6765 Gun Club Trail, Bed and Breakfast, AL-21-20

Please accept the following comments from El Paso County Public Health for the proposed bed and breakfast project referenced above:

Site Plan

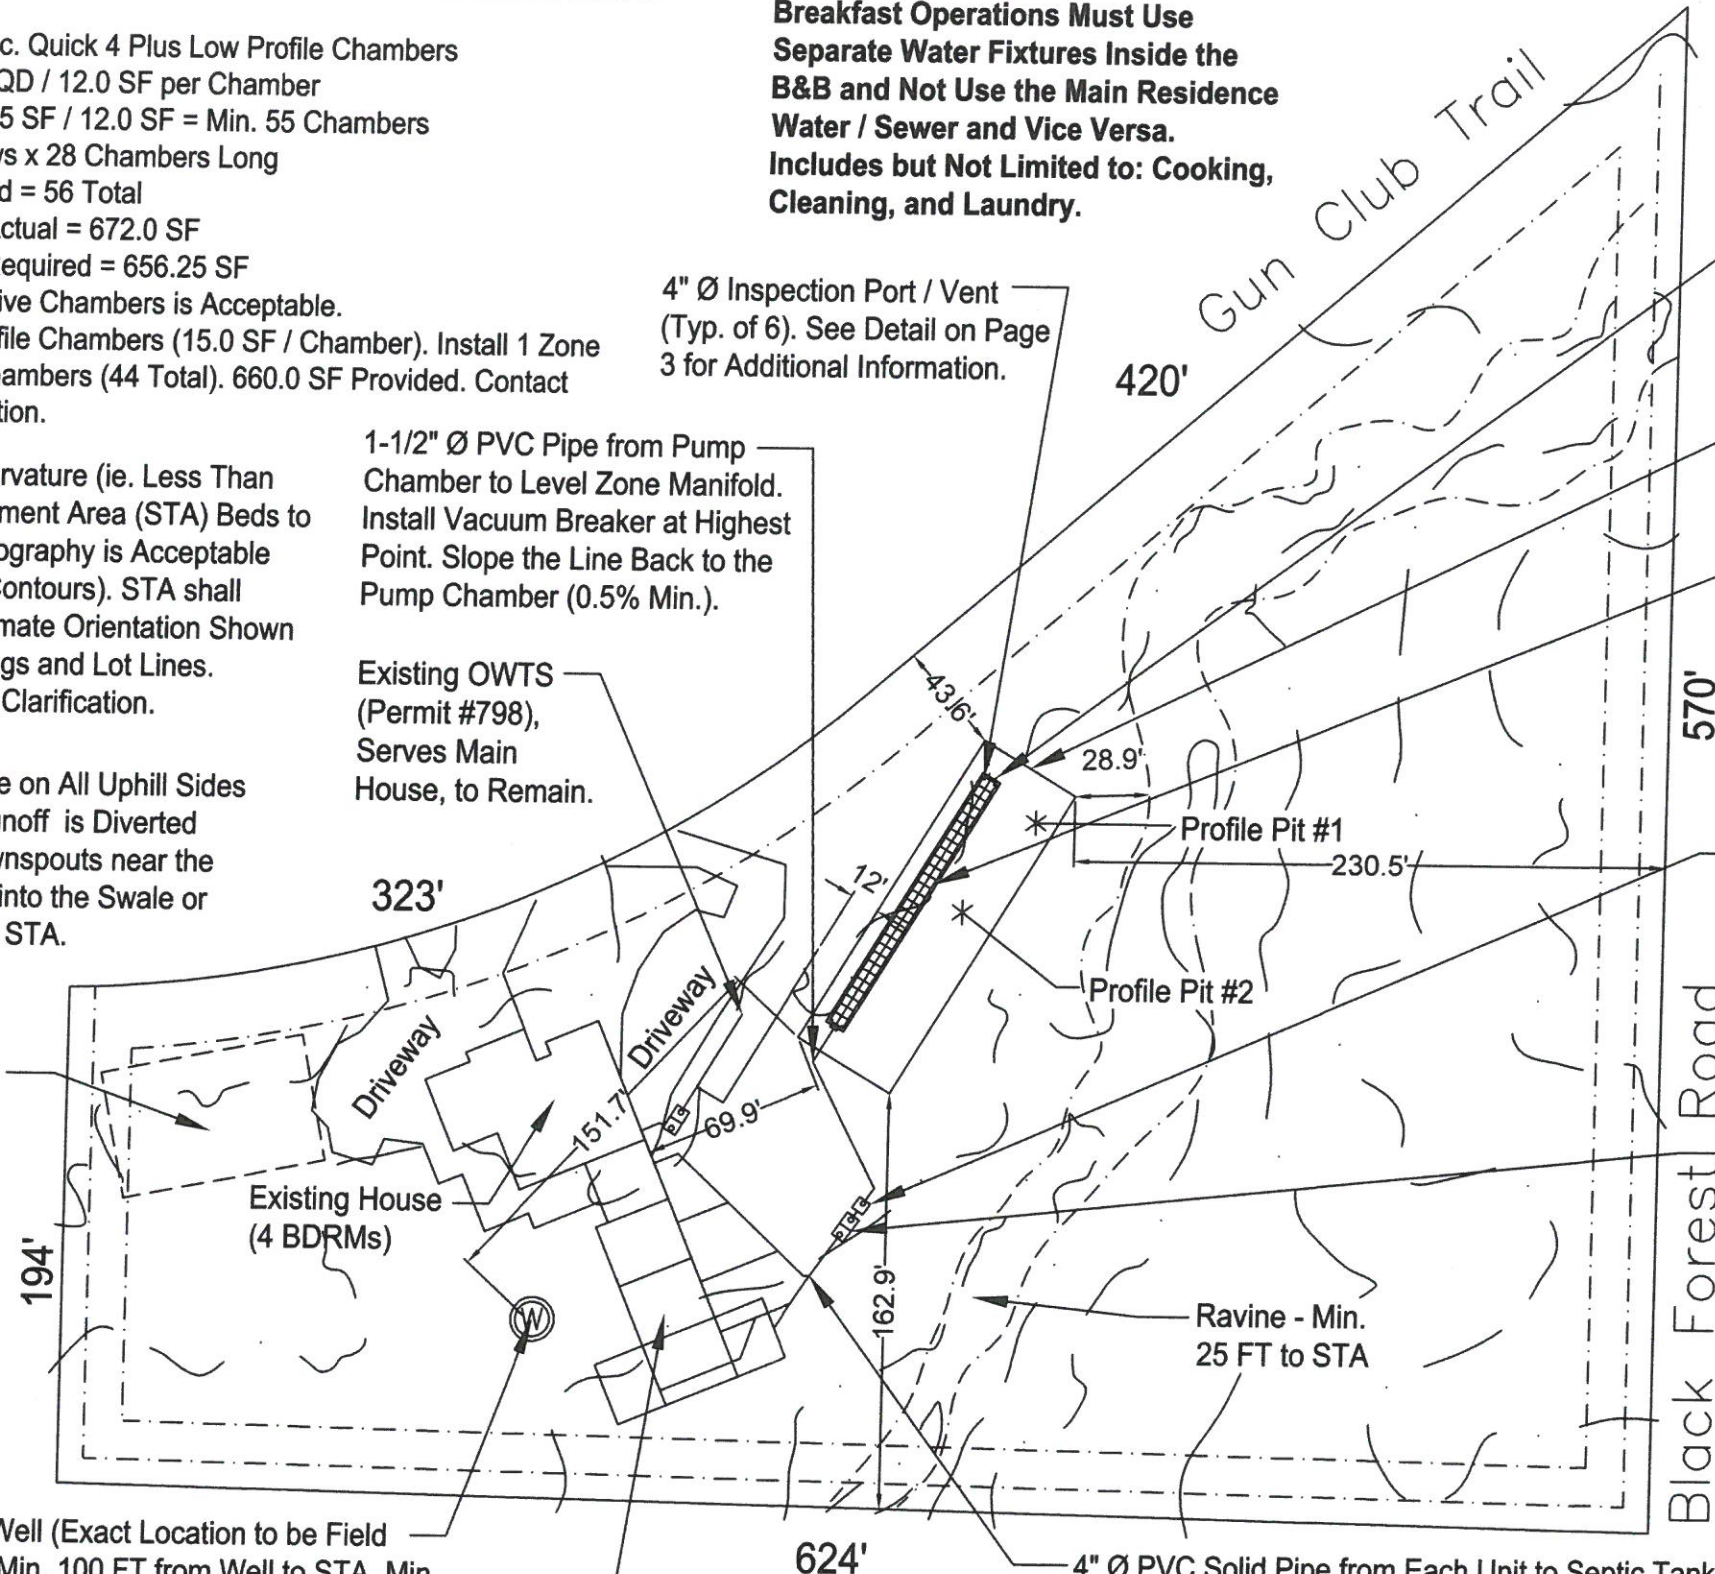
- Water service for the existing house is an existing individual private well.
- Wastewater service for the house is currently an onsite wastewater treatment system (OWTS) approved in 1980 for a 3-bedroom house. The bed and breakfast operation with 5 bedrooms and the potential for 11 total bedrooms in the future requires the new OWTS to be designed by a Colorado Registered Professional Engineer. The design is needed because of the operation being commercial verses residential. The design must be submitted and approved by El Paso County Public Health.

- Care must be taken to protect the proposed new soil treatment area (STA) from compaction during any remodel or parking area. We recommend the installation of temporary fencing to help identify and protect this future soil treatment area.
